Application: SSI 7485

I write regarding the proposed modification to M4-M5 Link, Mod 2 The Crescent overpass and changes to pedestrian infrastructure in North Annandale, Rozelle and Rozelle Bay Foreshore area.

Figure 4-2 Pedestrian and cyclist bridge infrastructure options

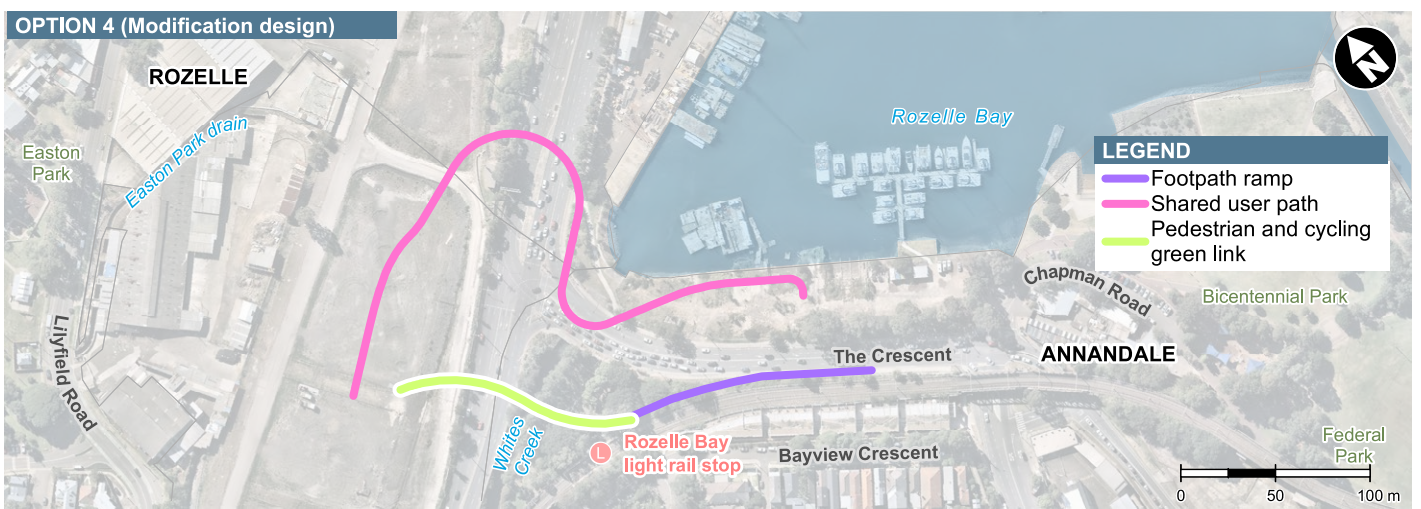
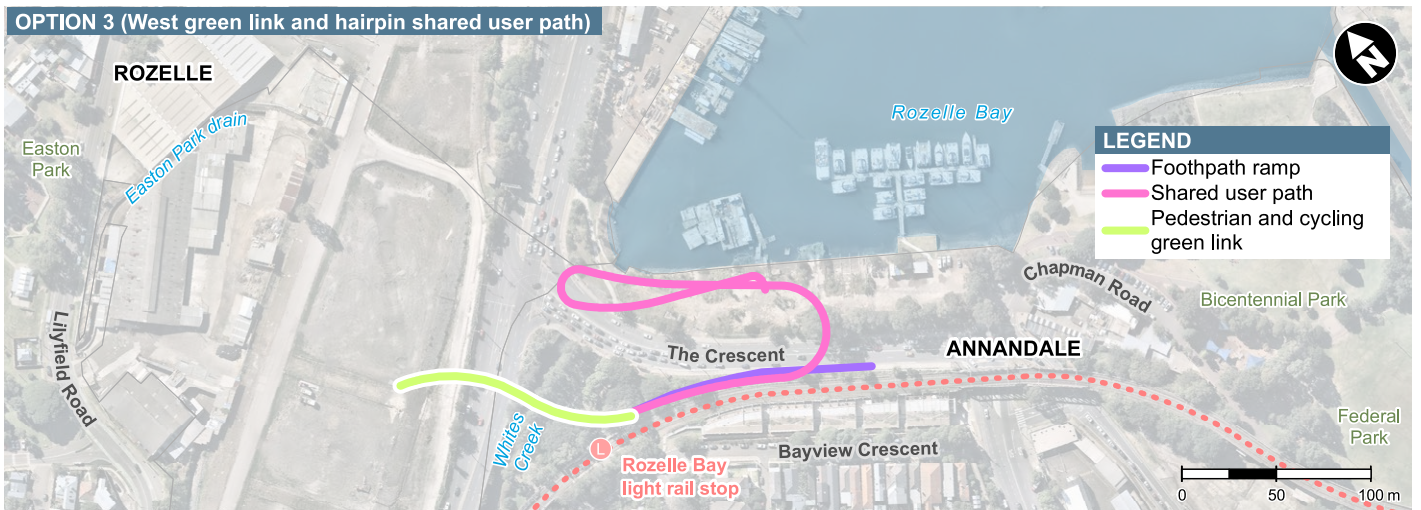
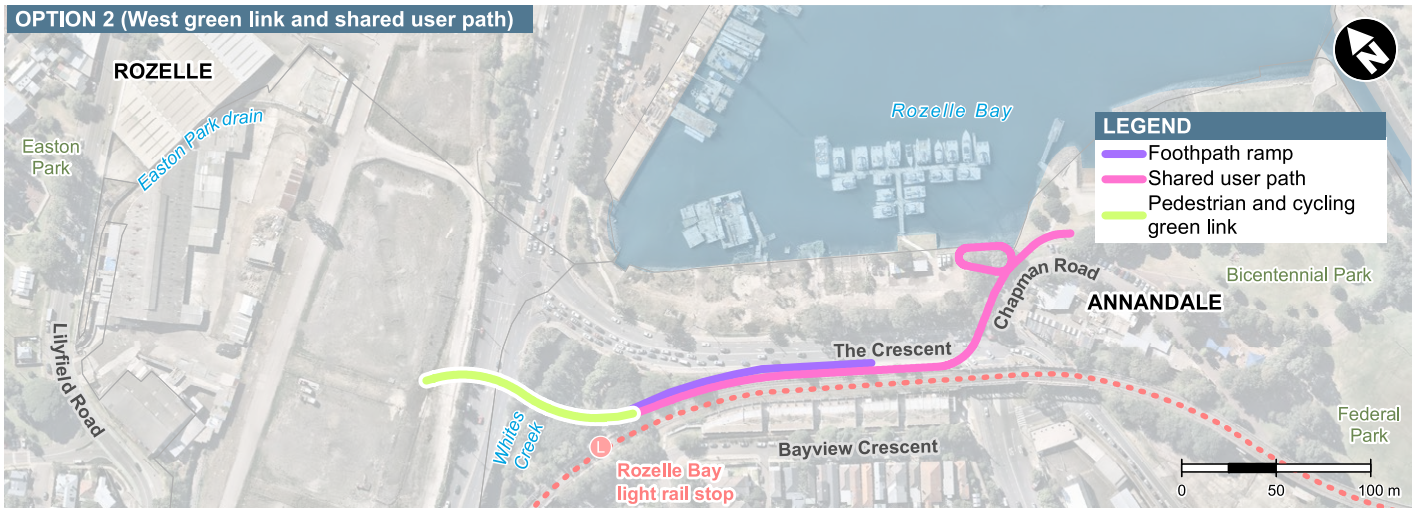
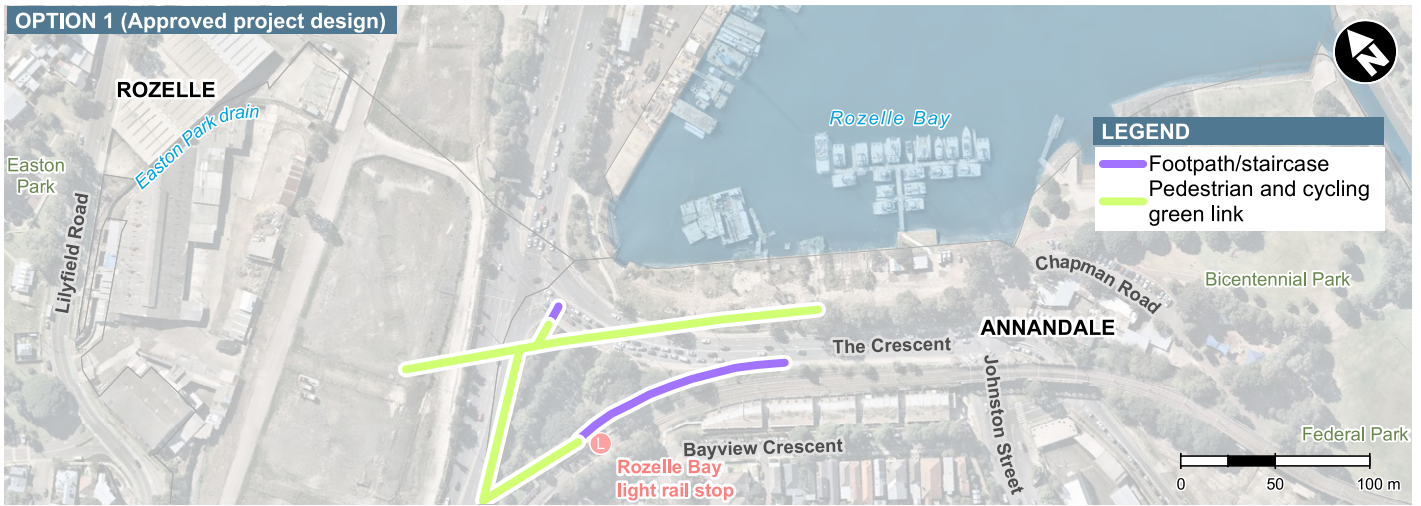
I request RMS work with the community to explore alternate design options to the proposed new car overpass design and the changed pedestrian and cyclist links. I am seeking the reinstatement of the safe, direct access from the approved EIS GreenLink to create a continuous green open space connection from the Rozelle Rail yards and Annandale to the foreshore. The GreenLink was more than just a walk way - it put people central to the design, maximising safety, and providing much needed accessible open space for the community now and into the future Bays Precinct design.

- Reinstate the GreenLink connecting communities and green open space from Rozelle to Bicentennial Park
- Relocate and design pedestrian and cyclist connections that are continuous, safe and direct.
- Design the modification infrastructure and active links in response to the character of the suburbs, the location of the foreshore and it's potential future development.
- Provide pedestrian and cyclist paths that maximise people safety and do not force them onto busier streets, unsafe concrete plazas and caged walkways.
- Integrate active and direct connections to all active transport – including the future Metro West and Foreshore Ferry Wharf

Figure 4-4 Elevation: Indicative view of The Crescent overpass

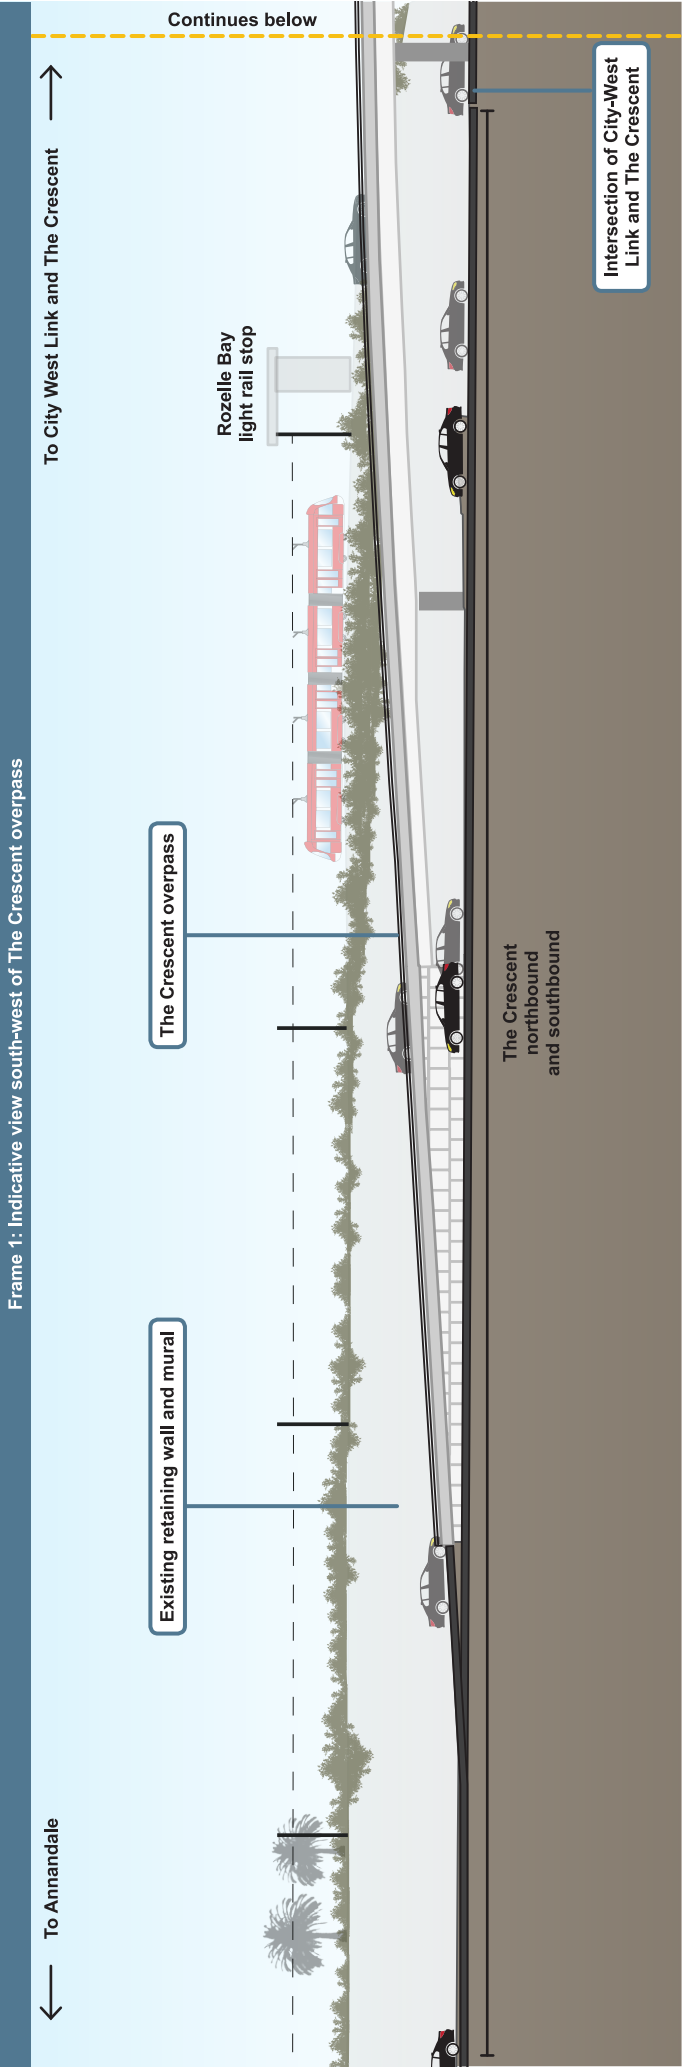
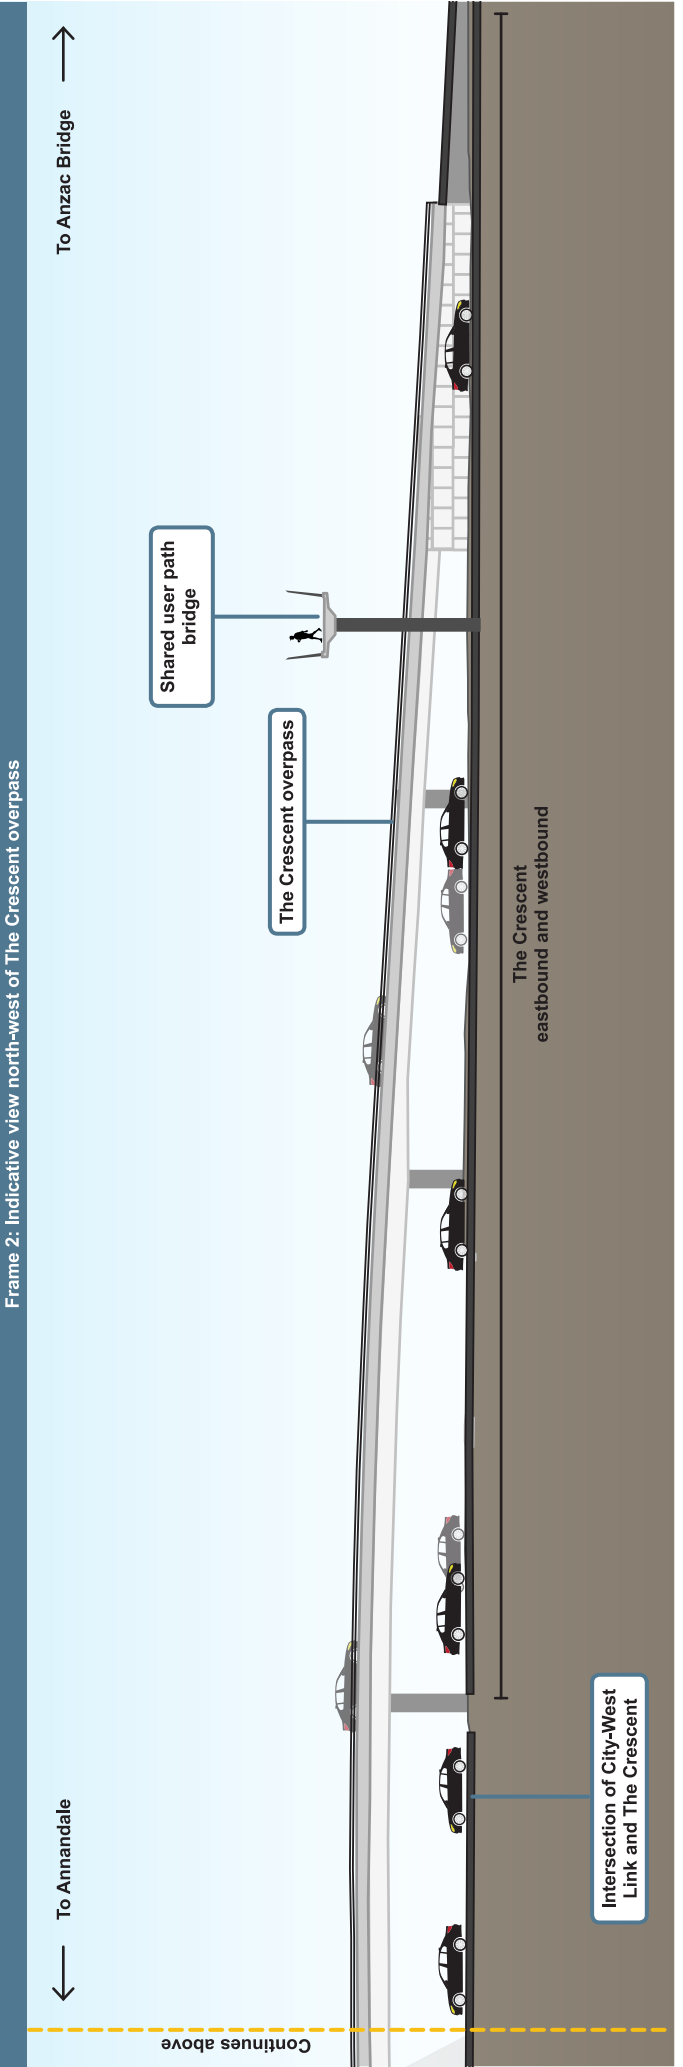
- The significantly reduced safety and increased risk for pedestrians and cyclists with removed access over The Crescent to Bicentennial Park and the increased traffic along Johnson Street.
- Being required to cross five sets of pedestrian lights at The Crescent as my option to reach the foreshore from Annandale or from Rozelle Bay light rail stop.
- Removal of direct active links to the foreshore, cutting the community off from the area and the proposed revitalisation of the entire Bays Precinct, including linking the Light Rail and Bus stops to a Ferry wharf and Metro station.
- Urban and landscape design that is being built before a finalised Masterplan for the area.
- Traffic changes that limit movements around the suburb and create further congestion in the local streets of Annandale, Forest Lodge, Glebe, Lilyfield and Rozelle with no planning to deal with these.

The removed access over The Crescent has significant safety concerns. Bicentennial Park contains a child care centre, childrens playground ^{and} a significant leash free dog area. In addition a busy timber yard & joinery is at the entry point where people will ^{now} be forced to cross past to access the amenities in Bicentennial Park. The timber yard is frequently accessed by large trucks. This is a significant hazard for people like and dogs.
